Reference No:	2024/62/93588/W
Site Address:	114, Slaithwaite Road, Meltham, Holmfirth, HD9 5PW
Description:	Erection of two storey and single storey rear extension
Recommending Officer:	Joshua Merriman

HOUSEHOLDER DELEGATED REPORT

Application Number	2024/93588
Location	114, Slaithwaite Road, Meltham, Holmfirth, HD9 5PW.
Proposal	Erection of two storey and single storey rear extension.
Publicity end date	12/02/2025
Number of representations received	2 from 1 address
Kirklees Local Plan Allocation/Designation	The application site is located in a twice buffer area, but is otherwise unallocated in the Kirklees Local Plan.
Extension to Time (EoT)	No
Recommendation	Conditional Full Permission

Drawing number
01 B.

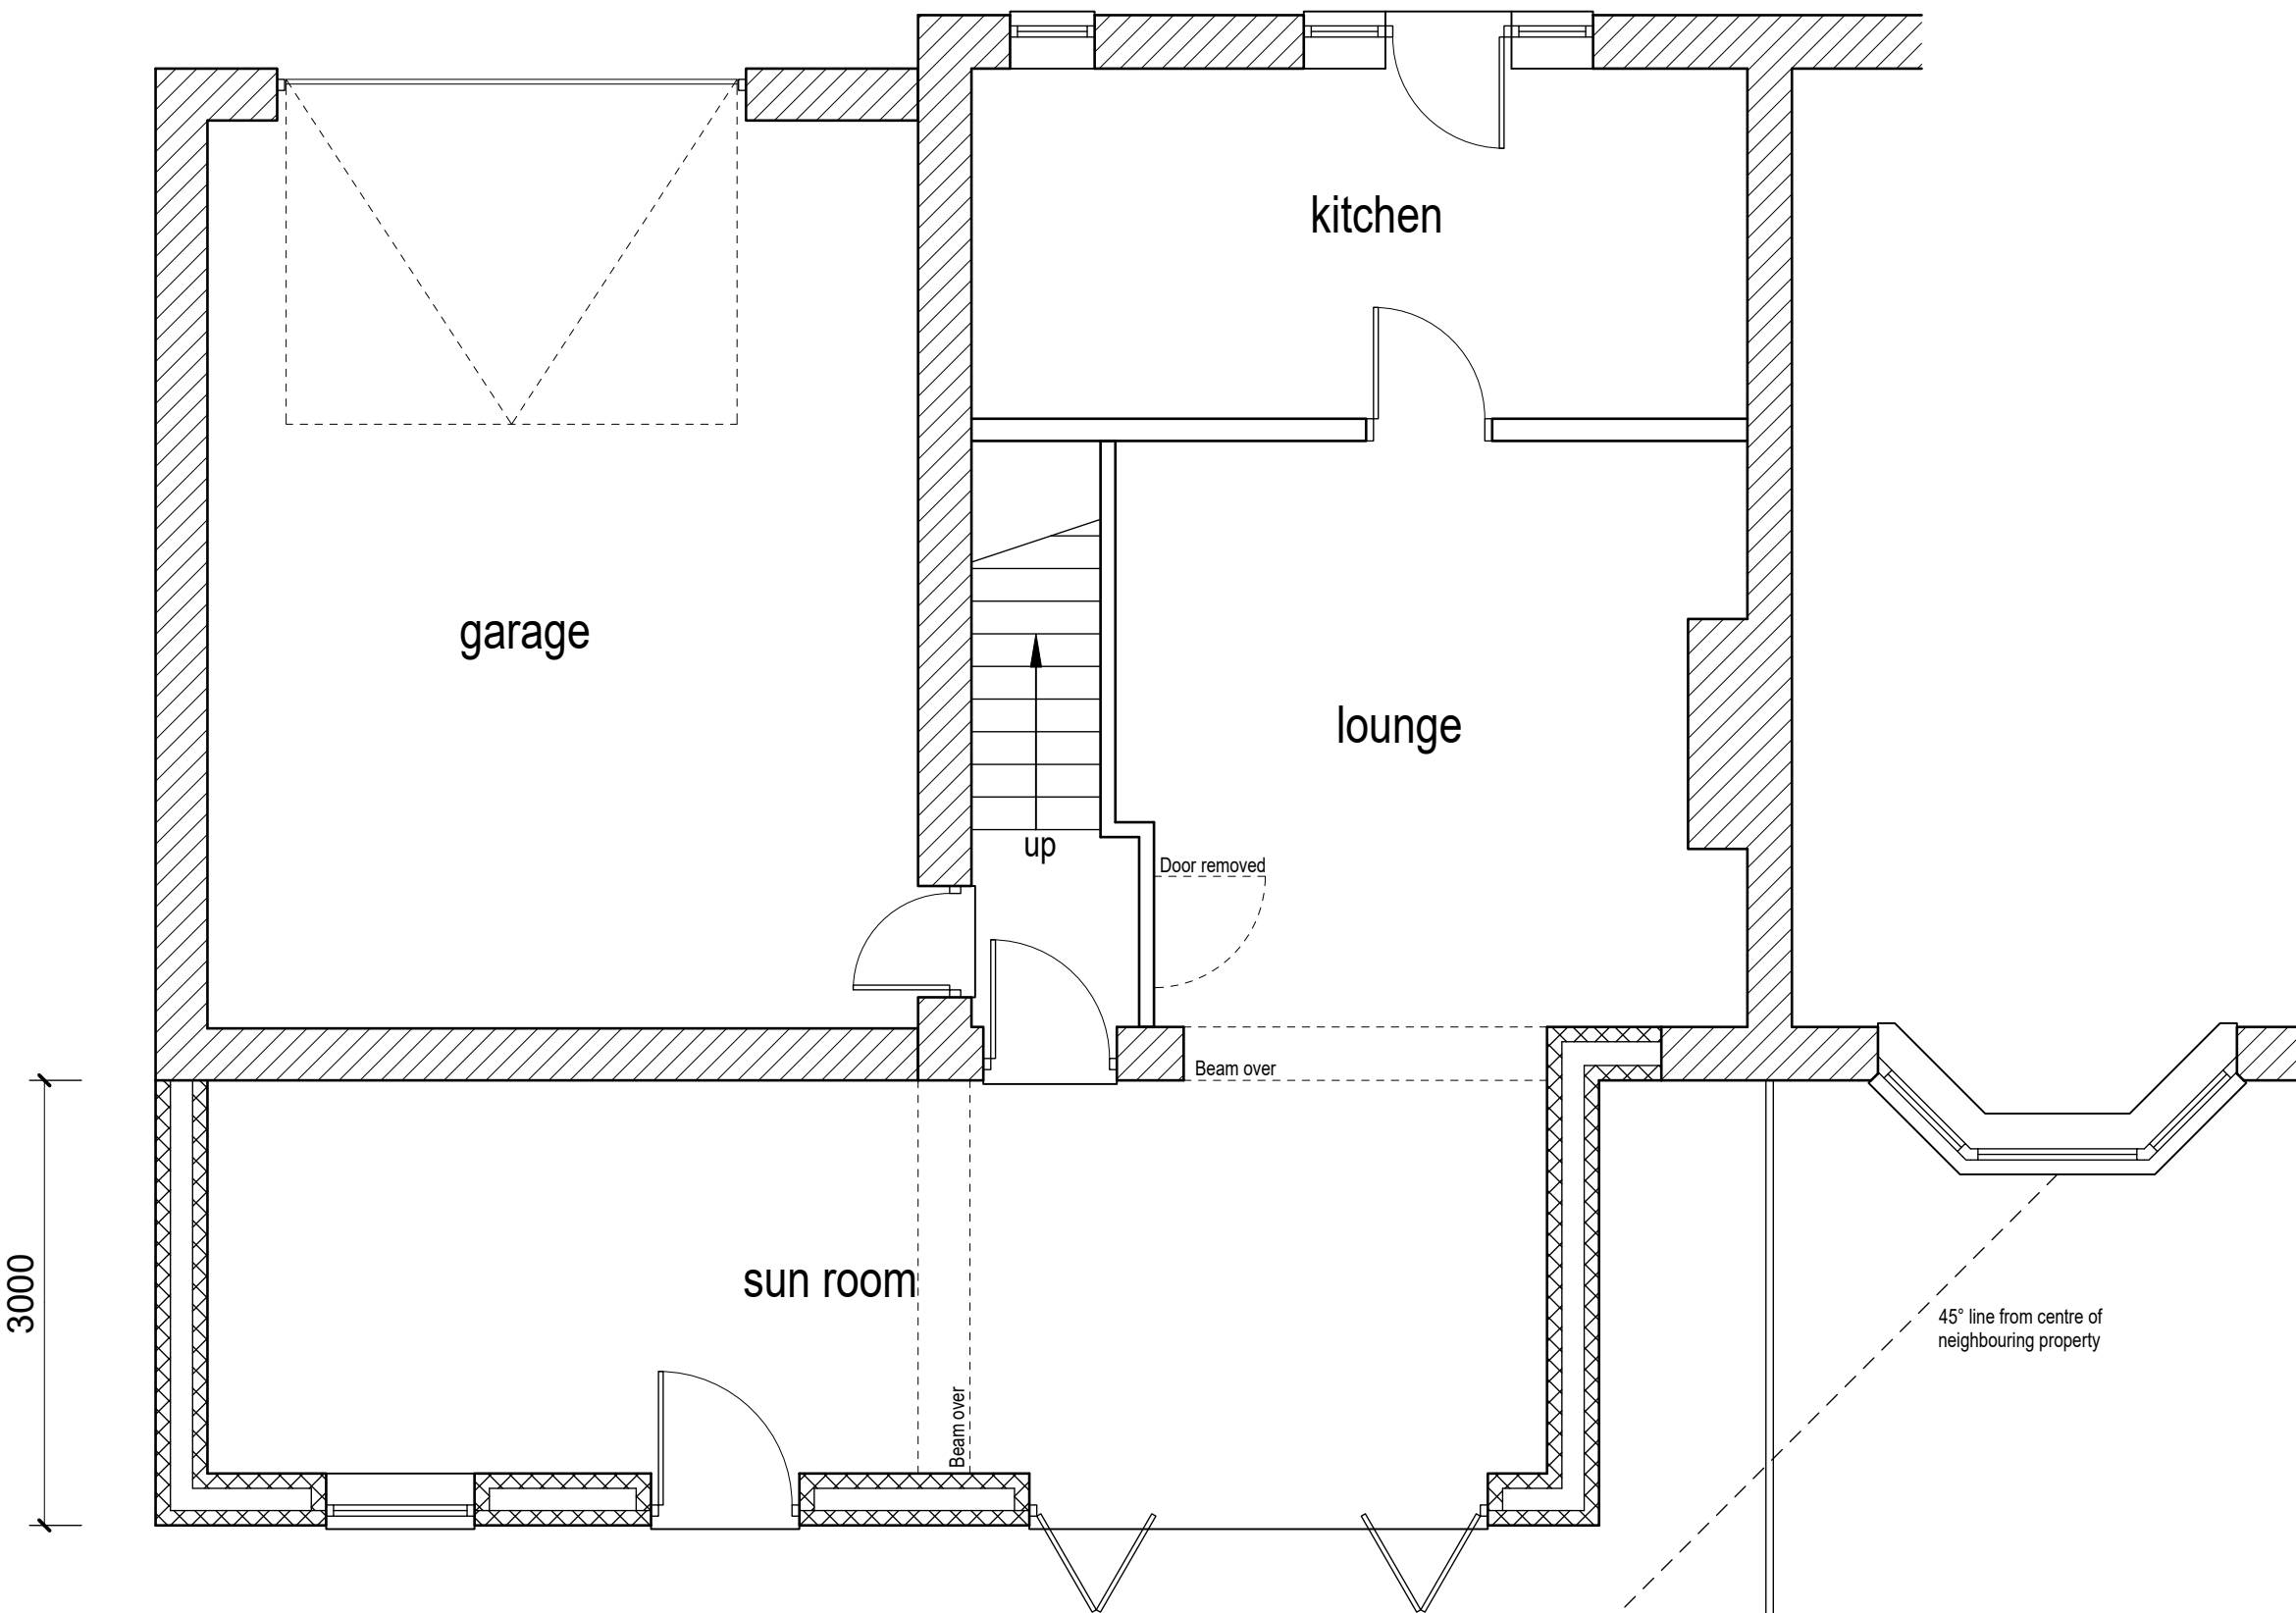
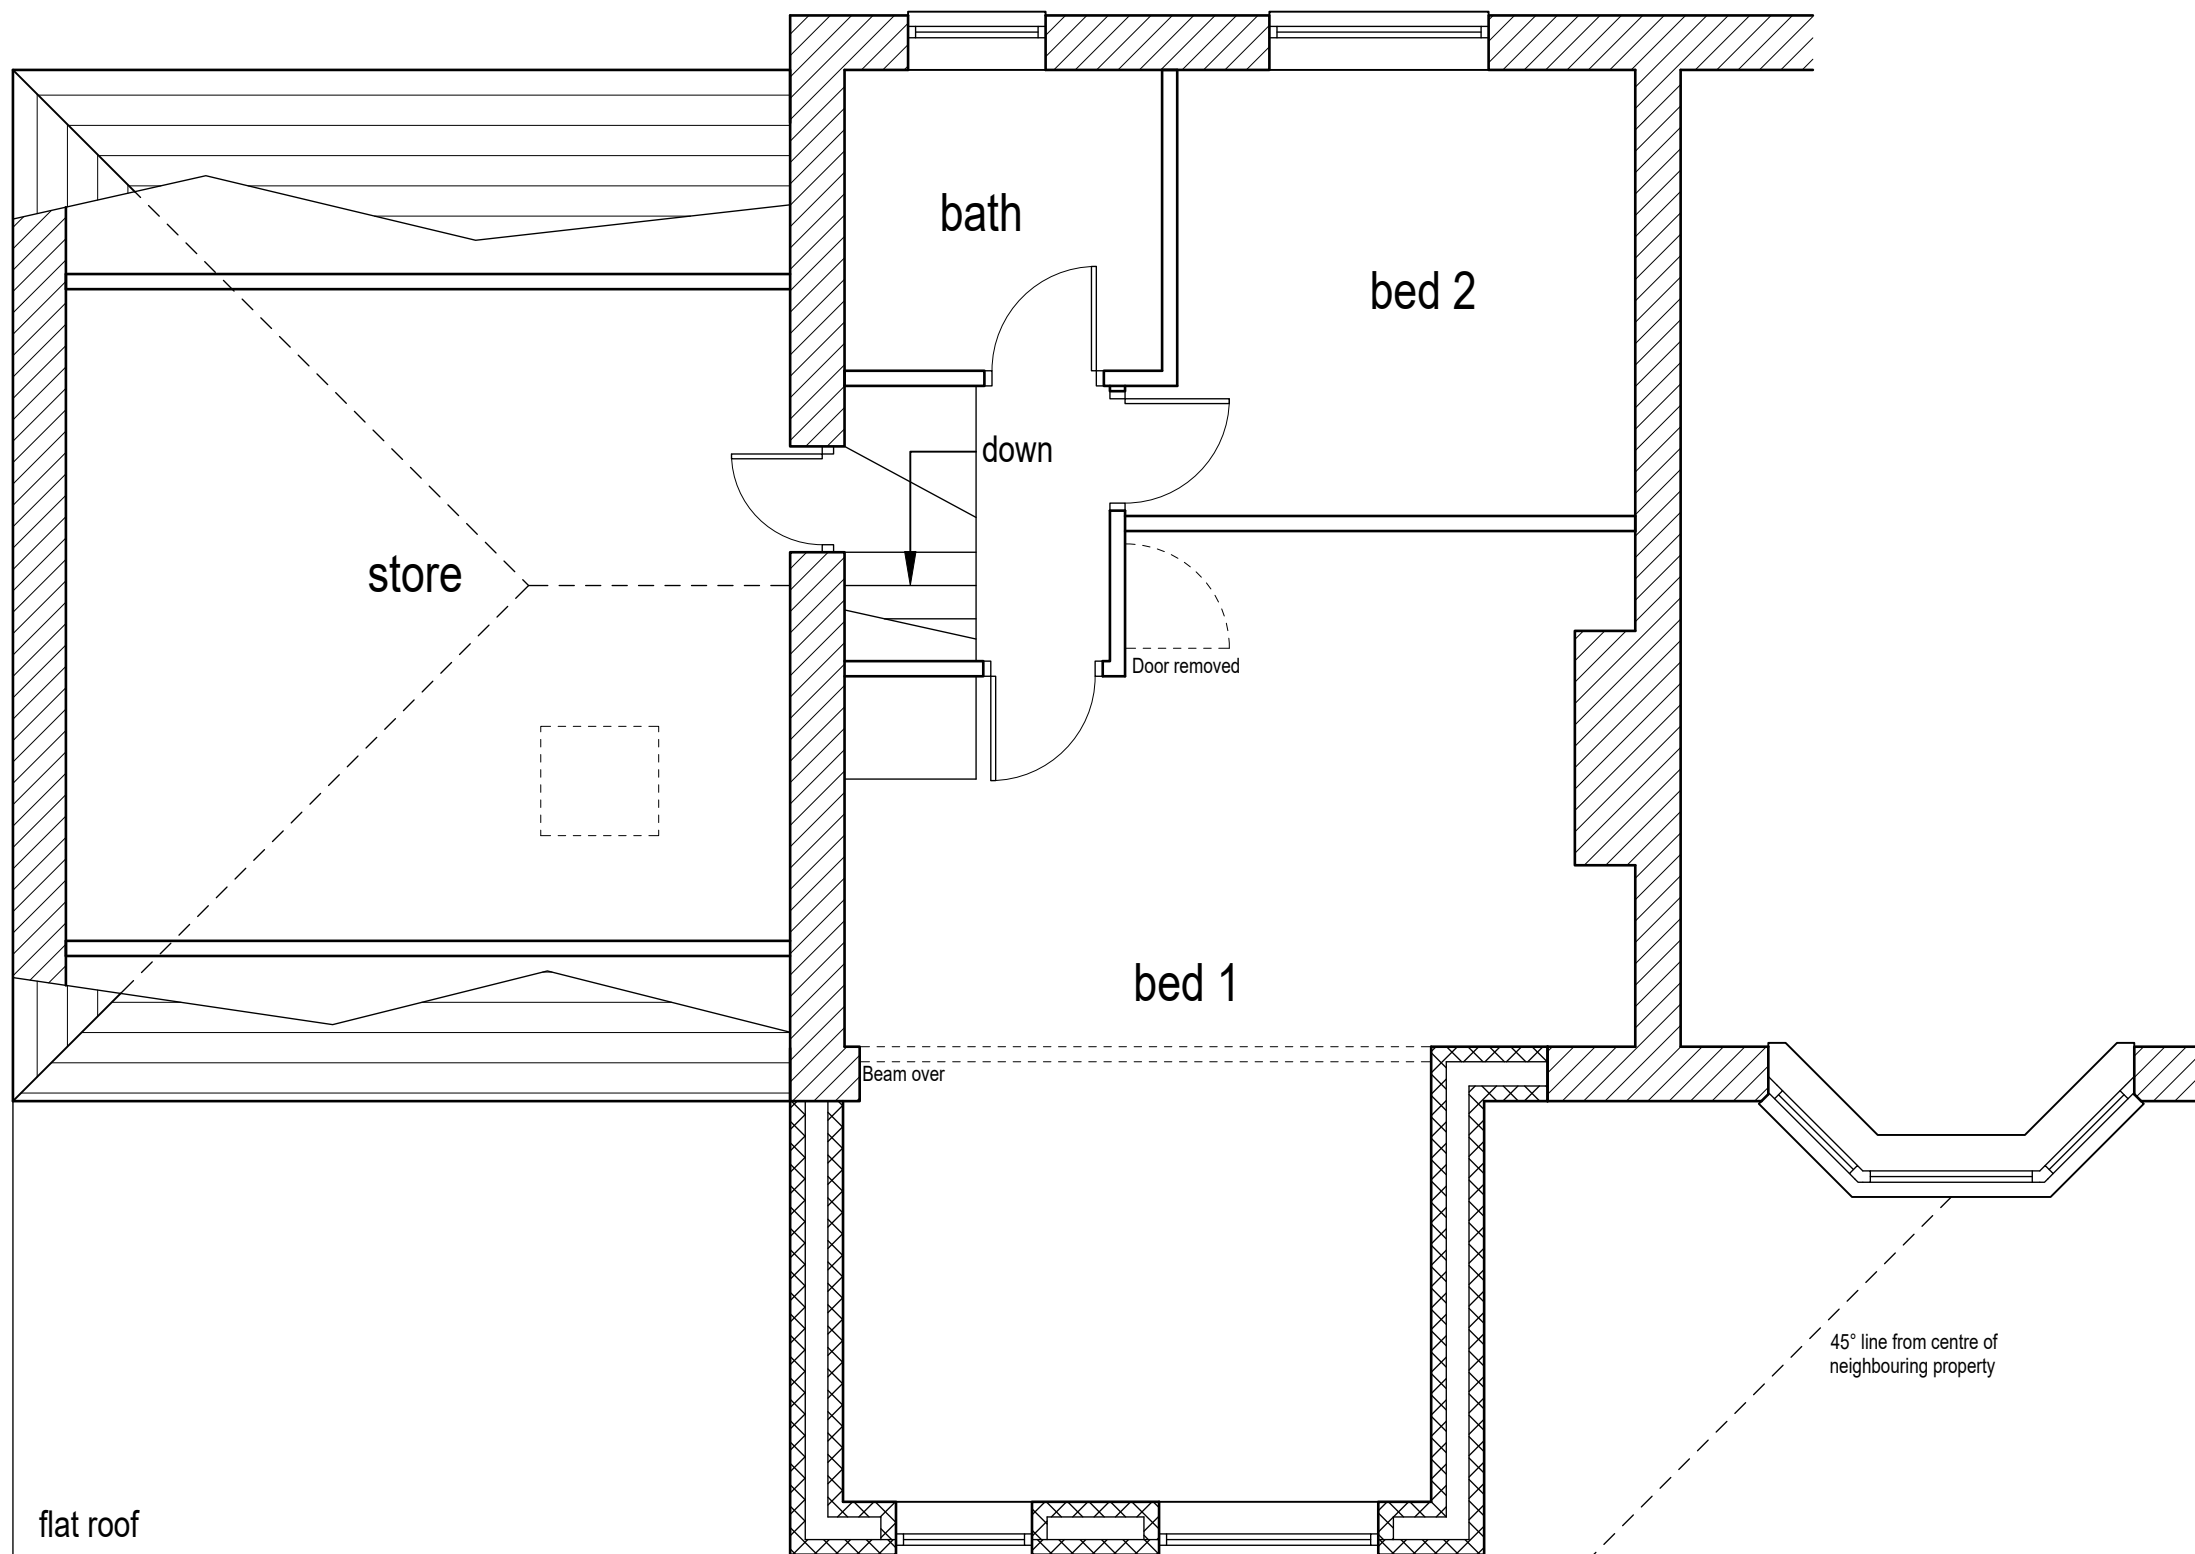
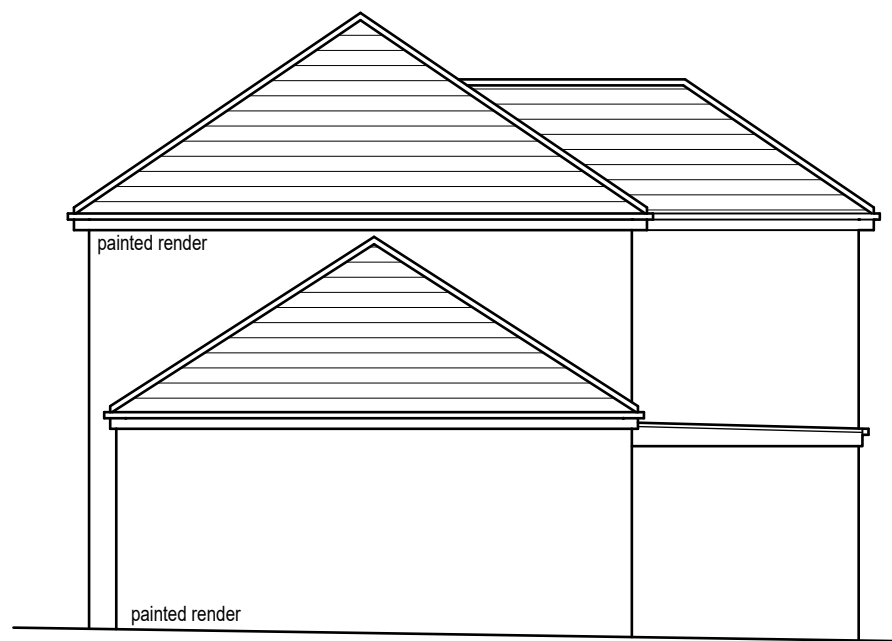
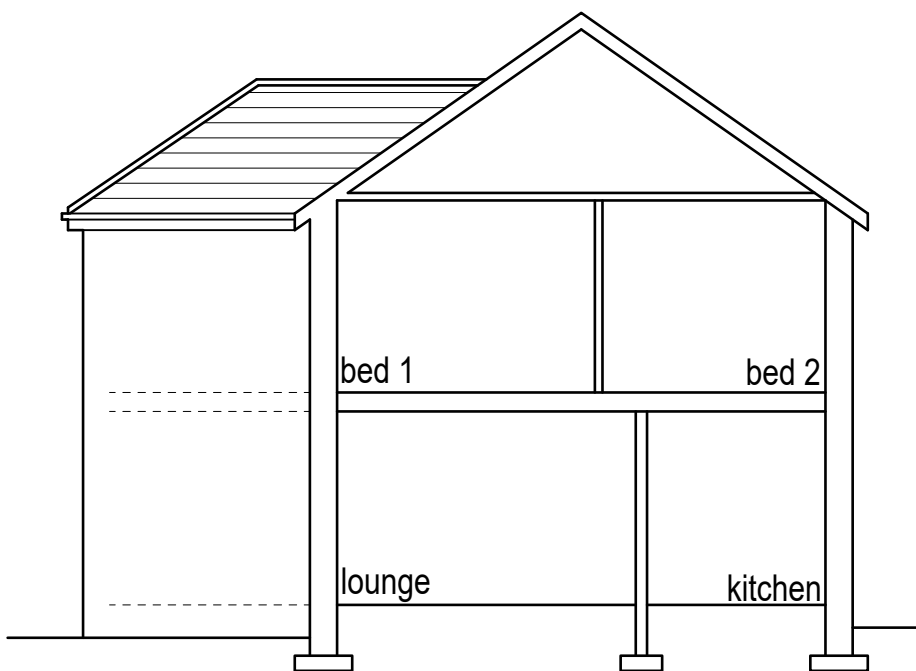
The proposed single-storey rear extension would project 3.22m from the rear elevation of the existing building, with a maximum height of 3m, eaves height of 2.75m, and a width of 5.51m.

The proposed two-storey rear extension would also project 3.22m from the rear elevation of the existing building, with a maximum height of 7.92m, eaves height of 5.82m, and a width of 4.92m.

where they exceed 3m in length the eaves height should generally not exceed 2.5 meters		Where the proposed extension exceeds 3m in length the eaves height is 2.75m, exceeding the 2.5m guideline. Despite this, as mentioned above, this is considered an insignificant breach that will have little impact on neighbouring dwellings and is therefore deemed acceptable.
retain a gap of at least 1 metre from a property	A 1m gap is retained to the property boundary on both sides of the

not exceed a height at the eaves of 3 metres where the extension is within 1.5 metres of the property boundary		The two-storey rear extension would exceed an eaves height of 3m where within 1.5m of the property boundary, however, as explained above due to the proposal not intercepting the 45-degree angle to the centre sill of the closest neighbouring window, it is not considered to have a significant

impact on the neighbouring dwelling. Considering this, the two-storey rear extension is acceptable in this regard.
be separated from the property boundary, such as a wall, fence or hedge, by at least 1.5 metre		The extension is only set 0.22m away from the property boundary, however, this is considered acceptable due to there being no significant impacts on the neighbouring property as a direct result of this.
not adversely affect habitable room windows where they adjoin a neighbour's boundary	The 45-degree angle to the centre cill of the neighbouring windows closest to the proposals is not intercepted, therefore, it is considered that there will be no adverse effects on neighbouring habitable room windows that are great enough to warrant refusal.

neighbours (to sides, rear and front)	• Policy LP24 Design (b) • Chapter 12 of the NPPF	angle to the centre cill of the closest window in 116 Slaithwaite Road, it is considered that there will be no significant impact on light and outlook of neighbours.	
Impact on overbearing or overshadowing	• KDP 5, 6 of the SPD • Policy LP24 Design (b) • Chapter 12 of the NPPF	As aforementioned, due to the extensions not intercepting the 45-degree angle to the centre cill of the closest window, it is considered that there will not be any significant impacts regarding overbearing or overshadowing to warrant refusal.	✓
Remaining garden space of application property	• KDP 7 of the SPD • Policy LP24 Design (b) and (c) • Chapter 12 of the NPPF	The application property will retain at least 50% of its current garden space, which is considered an acceptable amount.	✓

Pursuant to article 35 (2) of the Town and Country Planning (Development Management Procedure) Order 2015 and guidance in the National Planning Policy Framework, the Local Authority have, where possible, made a pre-application advice service available, complied with the Kirklees Development Management Charter 2024 and otherwise actively engaged with the applicant in dealing with the application. The case officer sought it necessary to seek additional plans showing the 45-degree angle from the centre sill of the closest neighbouring window.
